KITTITAS COUNTY FIRE MARSHAL'S OFFICE

June 26, 2012

Re: Giard (BL-12-00011)

After conducting a review of the above named project, I have the following comments:

BOUNDARY LINE ADJUSTMENT		
PREPARED FOR		
RON AND DEBBY GIARD		
SECTION 22, T.21N., R.12E. W.M.		
KITITITAS COUNTY		WASHINGTON
DWN BY	DATE	JOB NO.
R.KITZ	7/11	11065
CHKD BY	SCALE	SHEET
R.BOGDON	1"=100'	2 OF 2

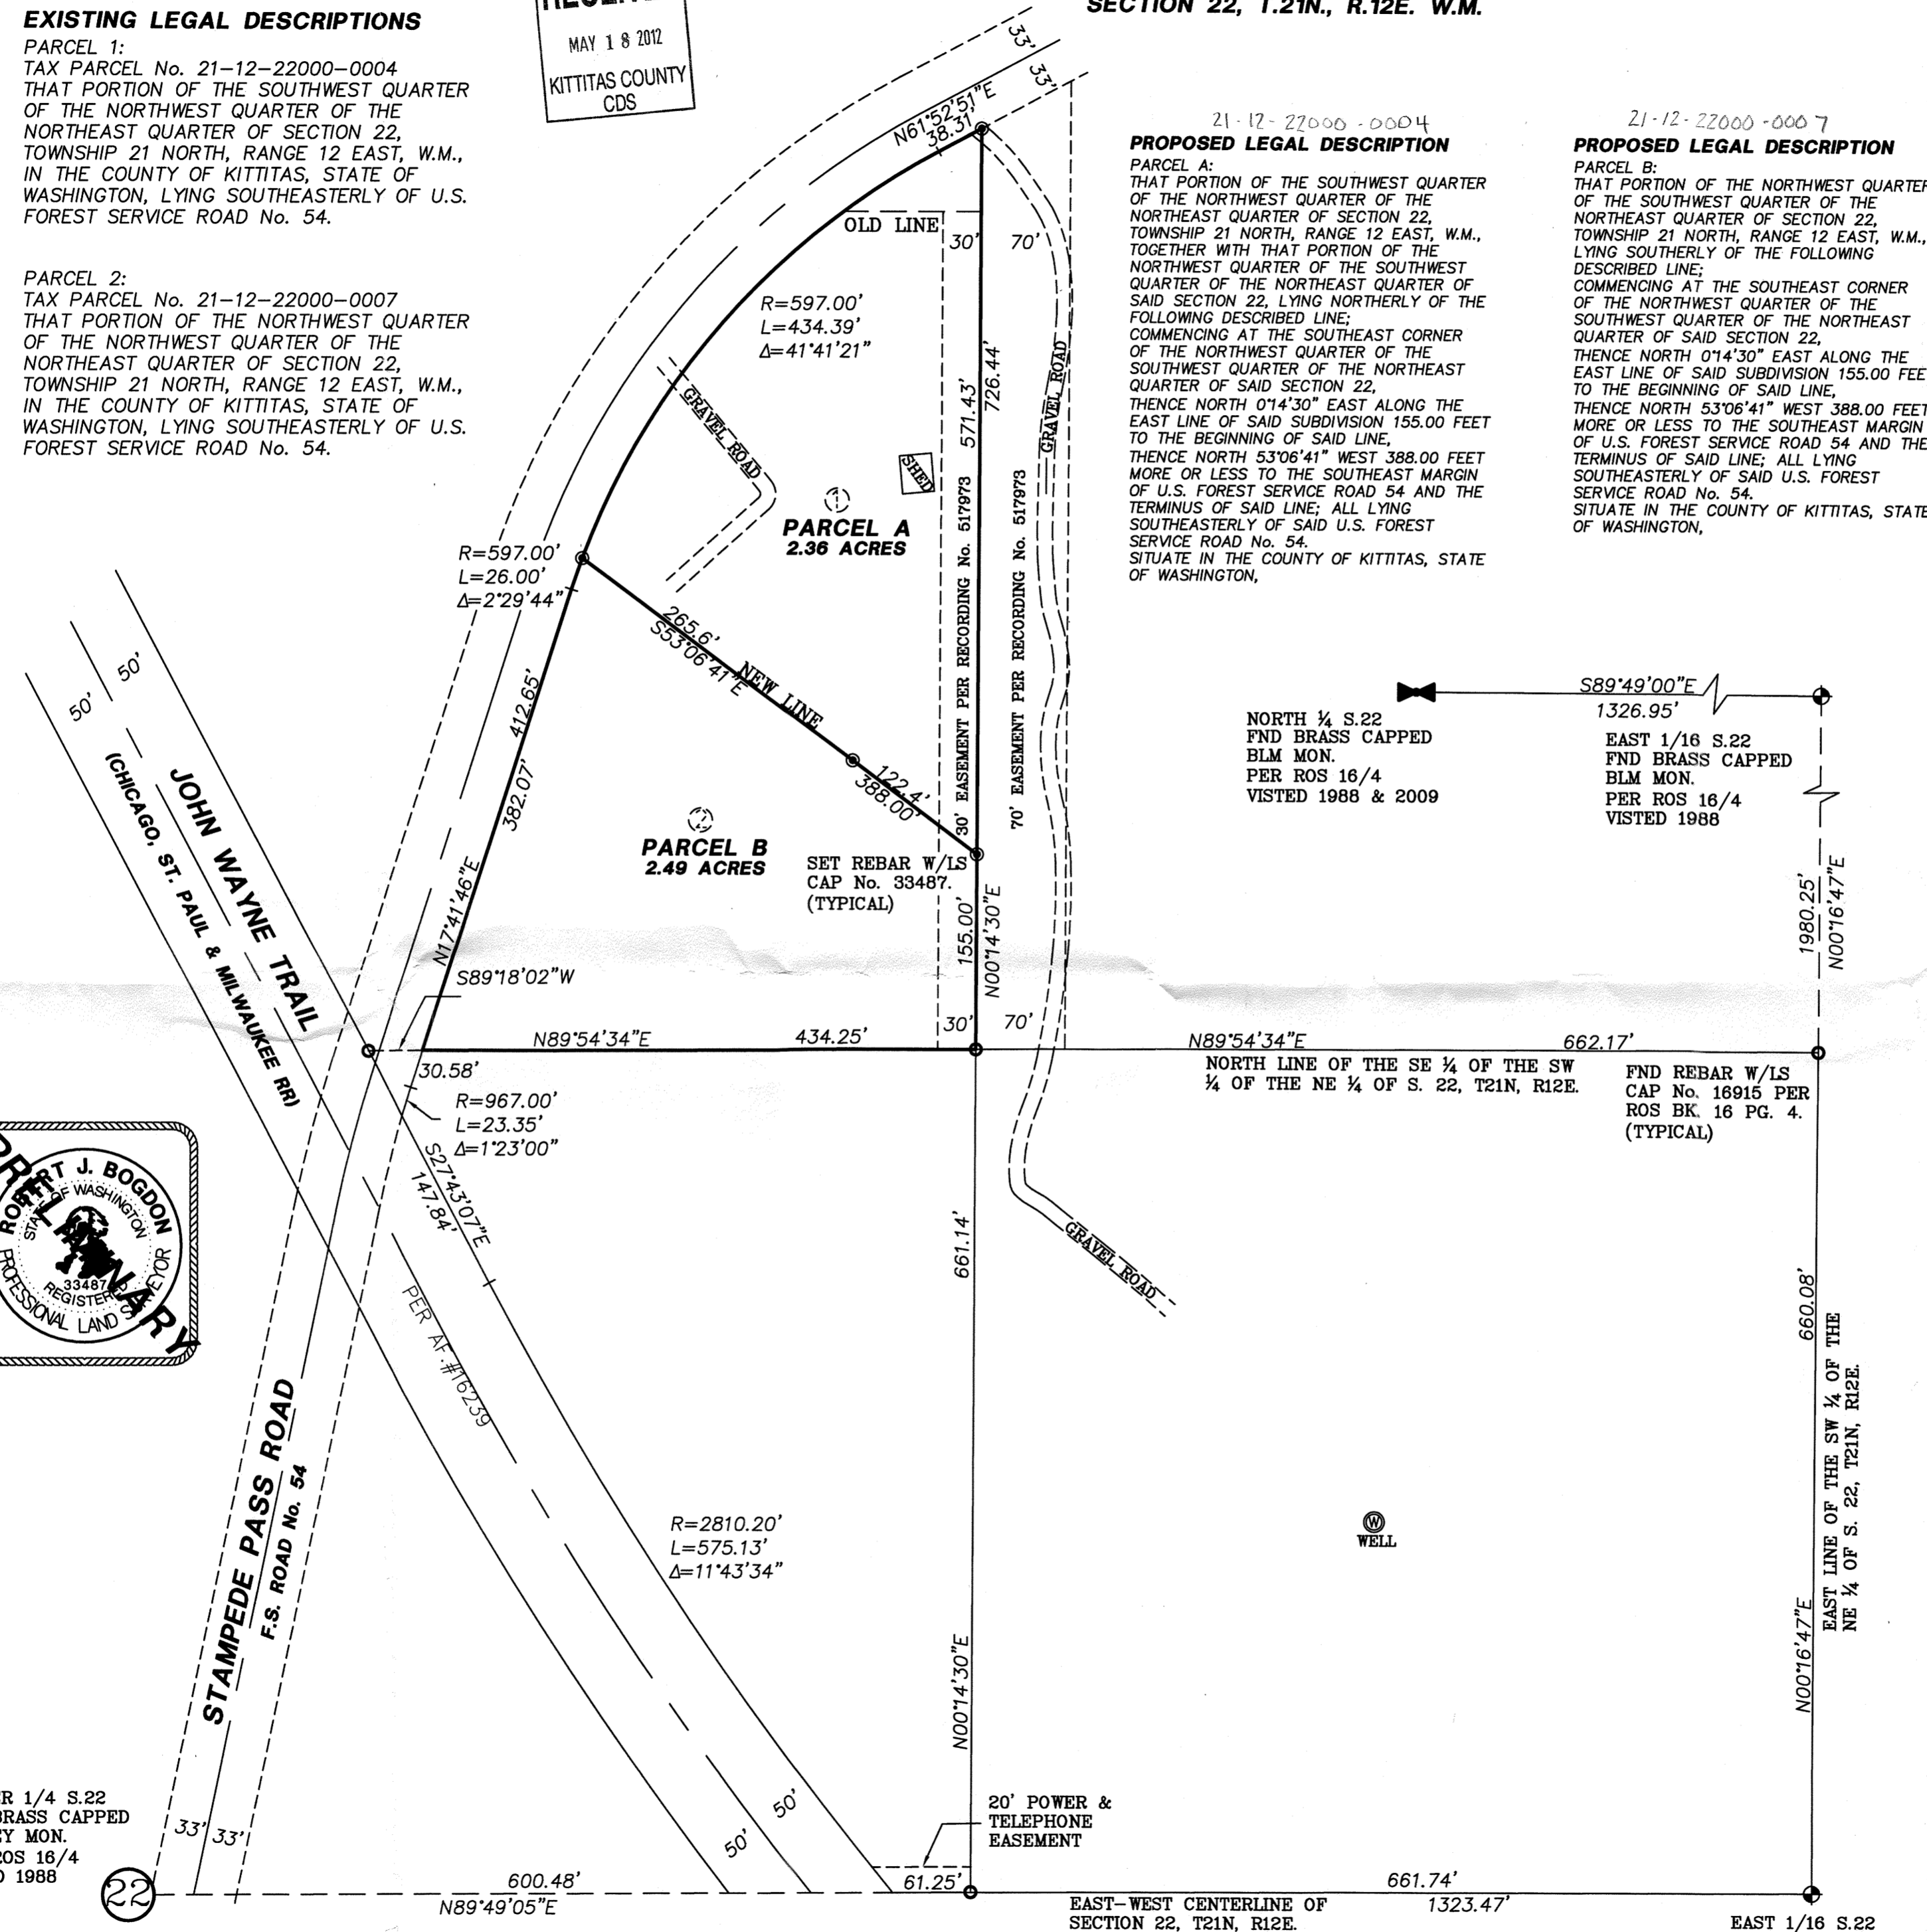
- Ensure that boundary line adjustments do not infringe upon existing structures, to include propane tanks, etc.
- Creation of any additional roads or access must comply with the International Fire Code and KCC Title 12.
- All future development must comply with the International Fire Code.
